No.	Natural England's Relevant Representation - Appendix E - Terrestrial Ecology	RAG status Rel and WR Rep	Consultation, actions, progression	RAG status D1	Consultation, actions, progression	RAG status D2	Consultation, actions, progression	RAG status D3	Consultation, actions, progression	RAG status D5	Consultation, actions, progression	RAG status D6
Appendix E - Terrestrial Ecology												
Environmental Statement - Chapter 5 – Project Description												
1	Design of new footbridge along the Roman Bank (sea bank) ECP – the new footpath alignment will alter the route of the ECP further inland. Natural England advises that full consultation would be required if the route were to be changed including an Appropriate Assessment.		Natural England have recommended that the Applicant continues to consult the English Coastal Path team on this issue and fully considers the implications of alterations to the route.		Please see Appendix E2 Deadline 2		NE note that in ISH2 the Applicant explained why they could not consider our ECP proposal. We will respond to any documents through examination.		Please see NE Deadline 5 Appendix E3.		N/A

**PUBLIC FOOTPATH CLOSURES
FIGURE 5.3**

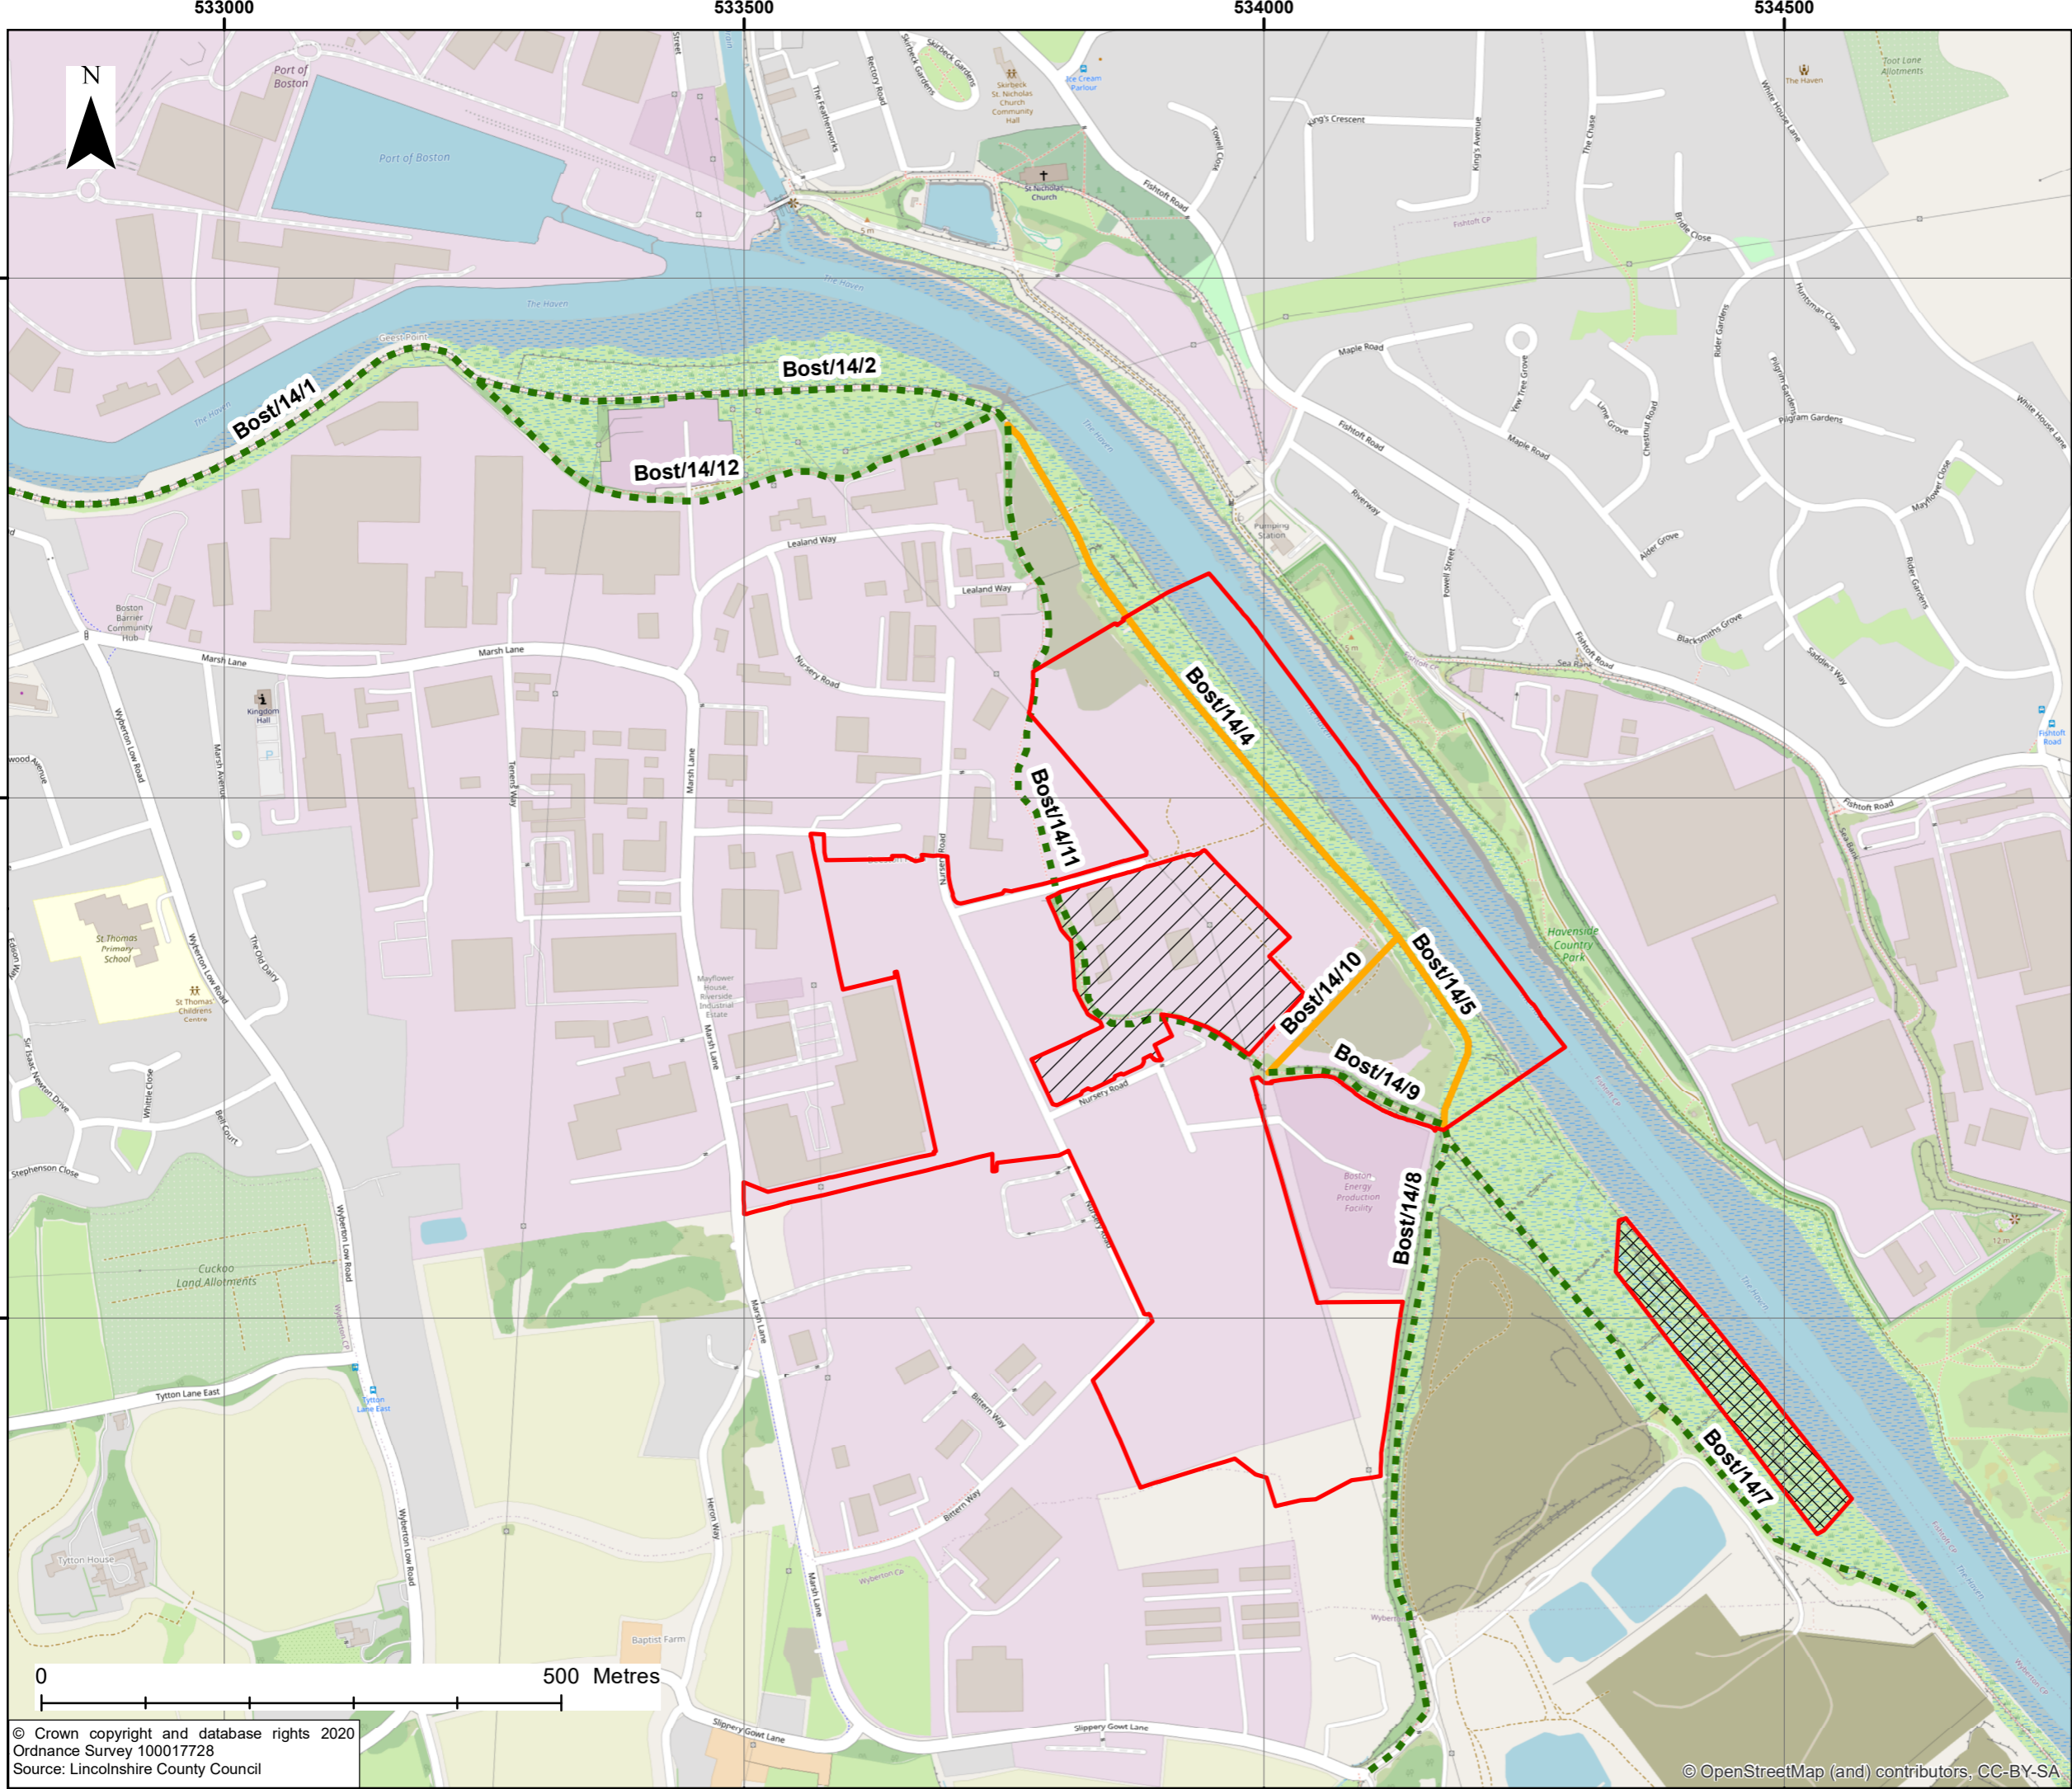
2	Fig. 5.3 shows English Coast Path – which is being diverted inland away from the channel.										N/A	
Environmental Statement - Chapter 12 – Terrestrial Ecology												
3	Natural England confirms that we believe that the surveys appear adequate. We agree that the surveys show low numbers of common species – Soprano Pipestrelle & Common Pipestrelle. Whilst we agree that the area concerned is low quality scrub/grass areas within existing industrial units, there is no indication of the route of transects so it is unknown if any bats are crossing the river when foraging.		Natural England have suggested that further right Bank transect may be required to assess this further.		No update		No update		We are waiting for NE specialist feedback on this matter.		Information regarding the route of 4 transects has been included at paragraph 5.1.3. of the updated OLEMS [REP3-008] and illustrated at Appendix 2 (drawing PB6934-RHD-01-ZZ-DR-4023). However, there are no details of any right bank transects. Is the Applicant intending to carry out this additional suggested transect? We note at 1.7 that the specific location and type of bird and/or bat box will be determined by a suitably qualified ecologist prior to the implementation of the final landscape mitigation planting scheme.
